Application No: F/4/20/OUT

Site Address: Land at Ford Airfield Ford

Thank you for your internet representation made on 17th January 2021 which has been recorded as an objection with the comments as follows:

These comments are made on behalf of the group "Friends of the Old Ford to Hunston Canal" FOFHC. There are a number of elements in this project which need to be amended or clarified.

FIGURE 7: MAY 2010 OPEN DAY MASTERPLAN

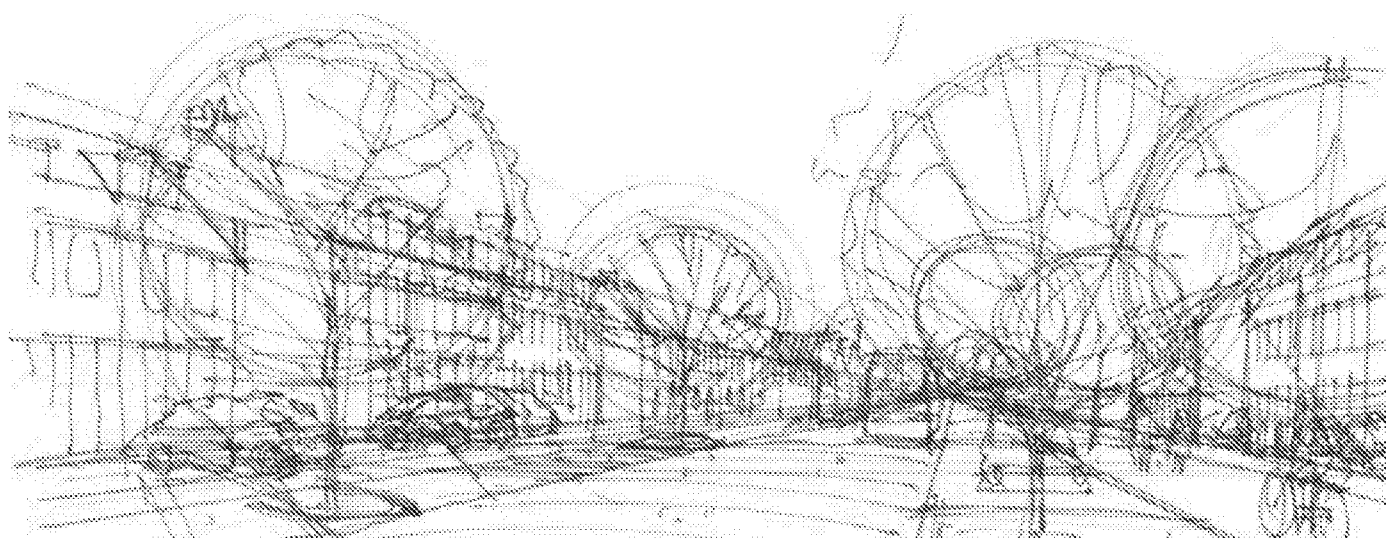
4) The original consultation documents showed a green space to the west of the Grundon site designated for sport (2018). The green dotted line looked as if a path had been allowed. This was an opportunity for a bio-diversity route incorporating the line of the canal. However the latest proposal shows 2 additional sports pitches which are not consistent with a through route.

FIGURE 23: KEY PRINCIPLES PLAN – PEDESTRIAN AND CYCLE MOVEMENT

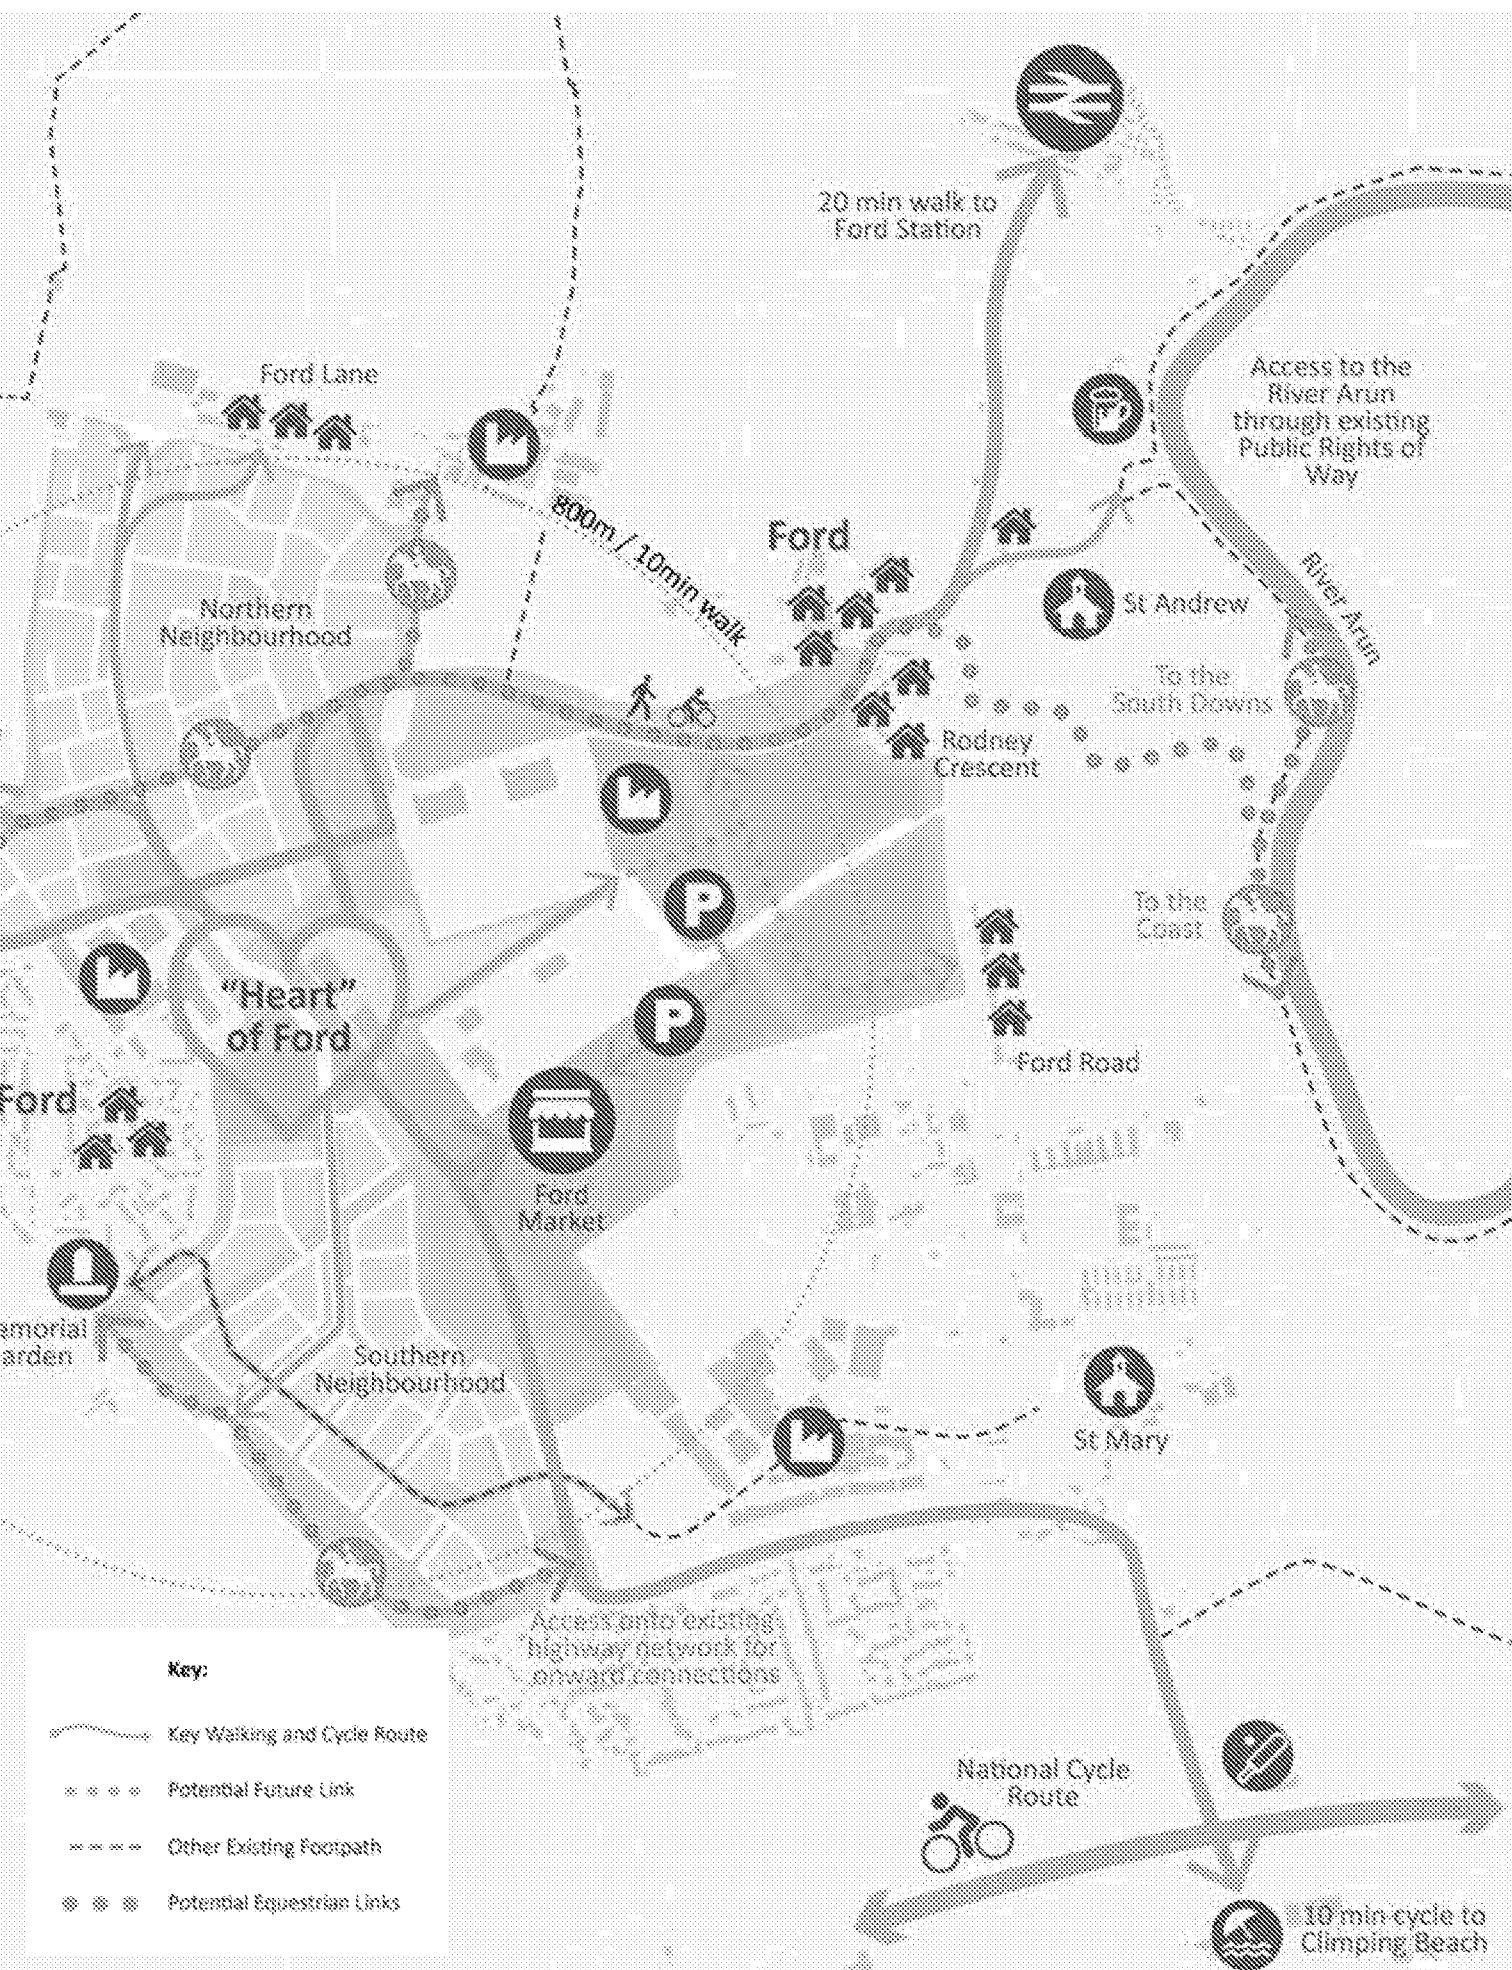
5) There is no defined west-east route shown for non motorised users which would connect the rest of Ford to the east as well as Yapton to the west. It is shown as a vague white dotted line.

6) There is a proposal ongoing supported by Sustrans to use the canal route from Ford to Hunston as a Greenway for non motorised users, pedestrians, cyclists, horse riders, and provision through this site should be made available for this purpose.

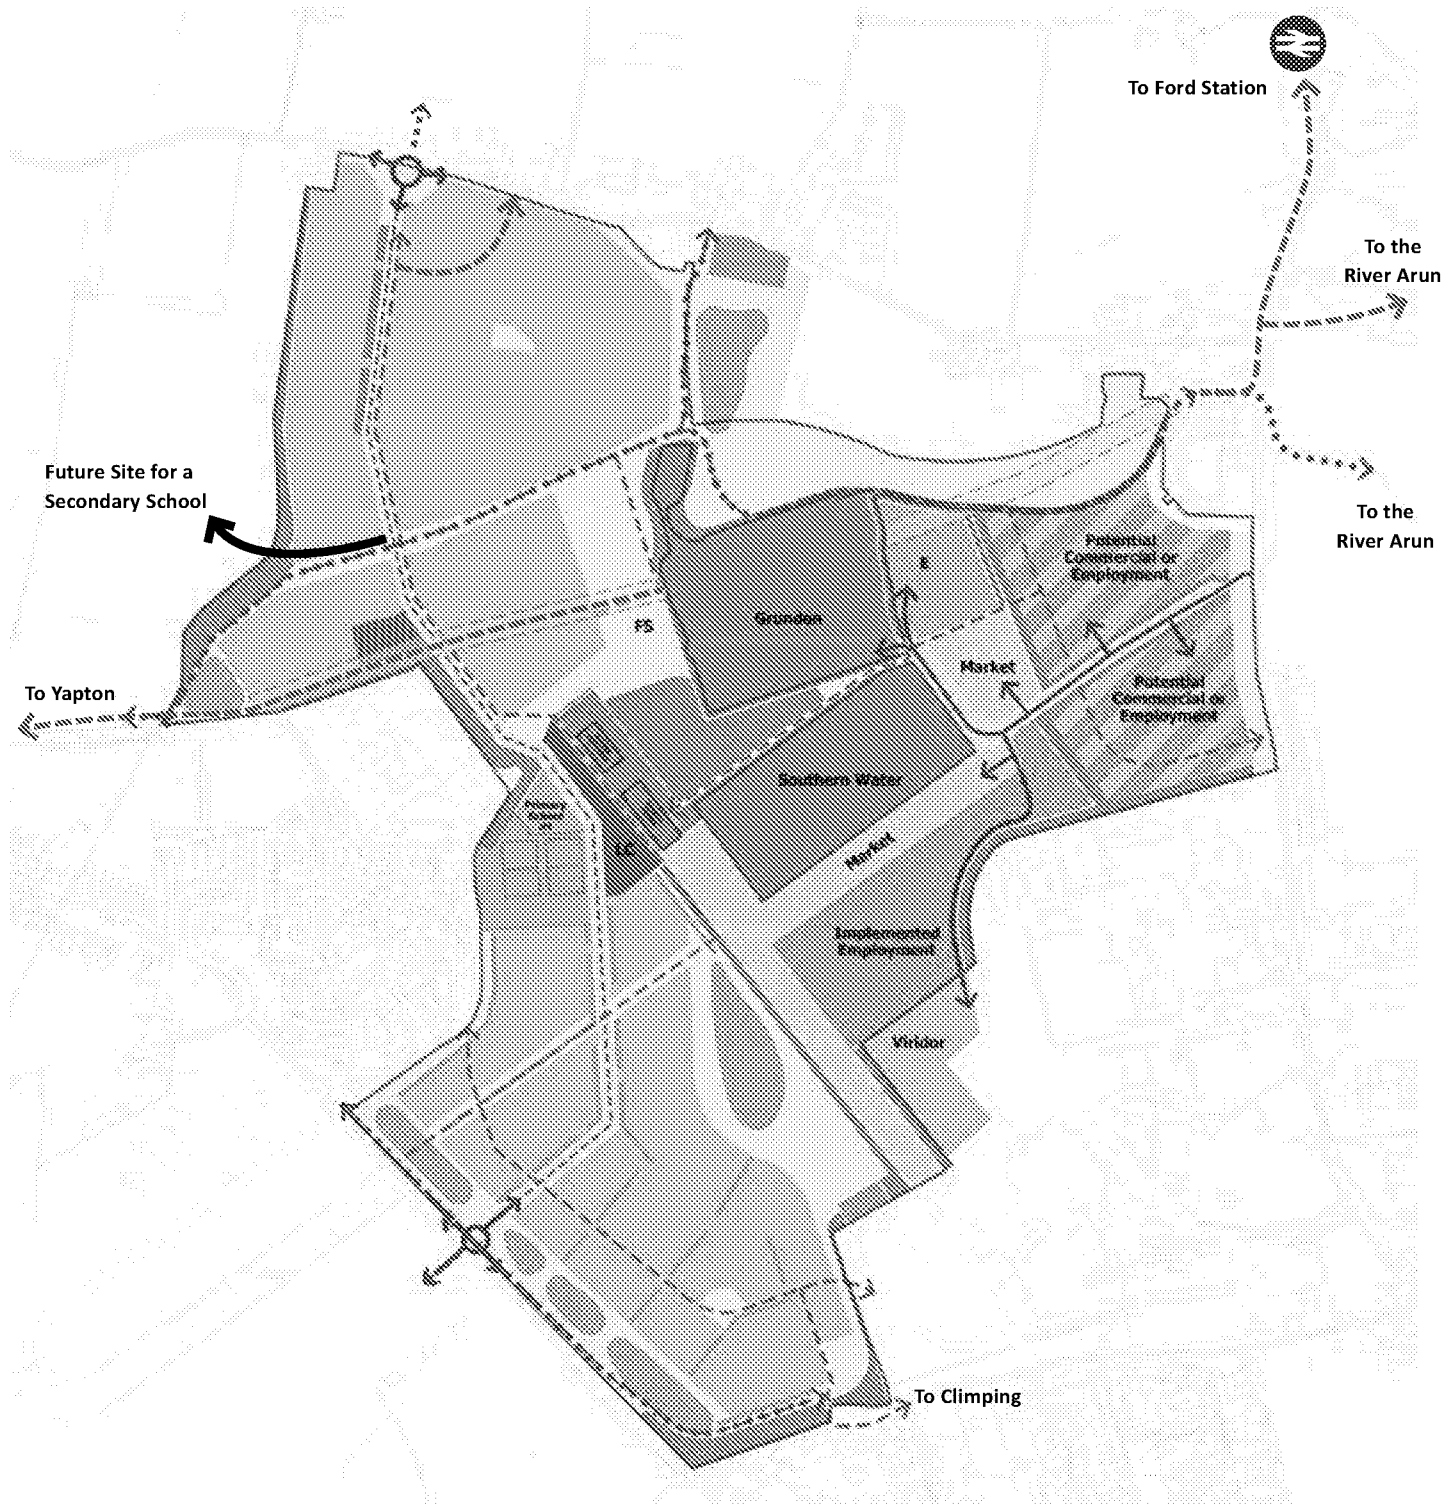
The Masterplan page 57 states 'the historic alignment of the old canal has been incorporated as a design feature in the form of a green corridor.'

We note that only a small section of the canal has been recognised with an abrupt end, whereas it should

continue beyond Grundon site. Whilst it is accepted that the original canal line runs through the existing Grundon site, there is an opportunity to extend the route around the north of the site and reconnect with the eastern portion of the canal route.
